OUT21/17501

**Forest Glen Solar Farm (SSD-9451258)  
EIS**

Alistair Drew  
A/Senior Project Officer, Assessments, Knowledge Division  
**Department of Planning and Environment: Water**  
19 January 2022

# Detailed advice to DPE Planning & Assessment regarding the Forest Glen Solar Farm (SSD-9451258) EIS

Figure 3-4 Hydrology Across the proposal site

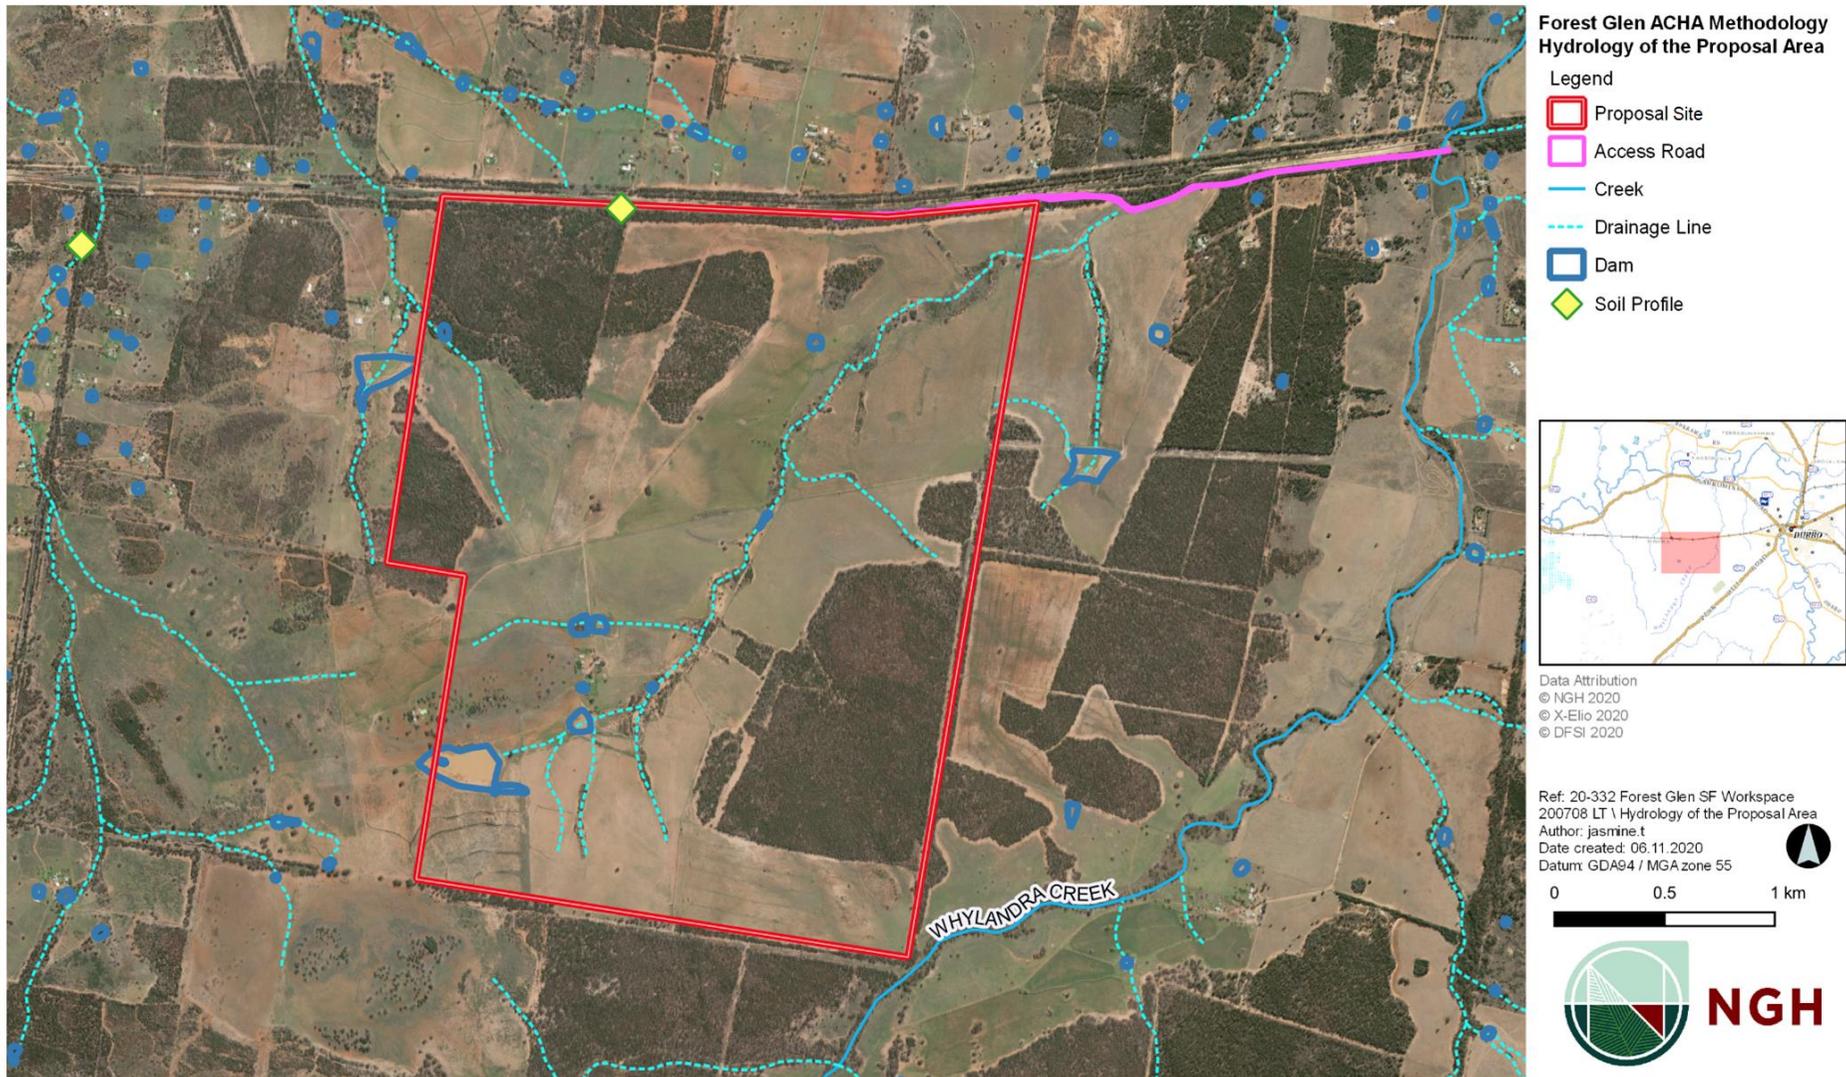
The proposal area includes a number of minor watercourses, including seven 1<sup>st</sup> orders and one 2<sup>nd</sup> Order. One new watercourse crossing is specified over the second order, however based on the perimeter road layout a significant number of crossings will be required over first order watercourses. The watercourse crossings will need to be in accordance with the *Guidelines for Controlled Activities on Waterfront Land* (NRAR 2018) (CAA Guidelines). The proposal has included a vegetated buffer for the second order watercourse which is consistent with the CAA Guidelines. Partial construction over some of the first order watercourses will need to ensure the maintenance of flow patterns to maintain downstream flows and to minimise erosion potential.

The site is characterised by erodible soils and there is evidence of sheet and gully erosion and sedimentation in drainage lines. Appropriate management of sediment and erosion control during all stages of the project will be critical to mitigate impacts to waterfront land. This will need to be addressed through development and implementation of site specific mitigating measures with a focus on avoiding surface disturbance in waterfront land and mitigating additional and altered runoff patterns due to infrastructure installation.

- The proponent should prepare a Construction Environmental Management Plan (incorporating a Soil and Water Management Plan) prior to commencement of activities. This should include measures to address sediment and erosion control in accordance with the guideline; Managing Urban Stormwater: Soils and Construction (Landcom 2004).
- Sediment basins should be designed in accordance with Landcom (2004) and will need to meet an excluded work definition in Sch 1(3) of the *Water Management Regulation 2018* to be exempt from water licensing requirements.
- Erosion and sedimentation mitigating measures and groundcover management should be designed to manage the soil erodibility risks during all stages of the project.
- Watercourse crossings and other works within waterfront land should be in accordance with the Guidelines for Controlled Activities on Waterfront Land (NRAR 2018).
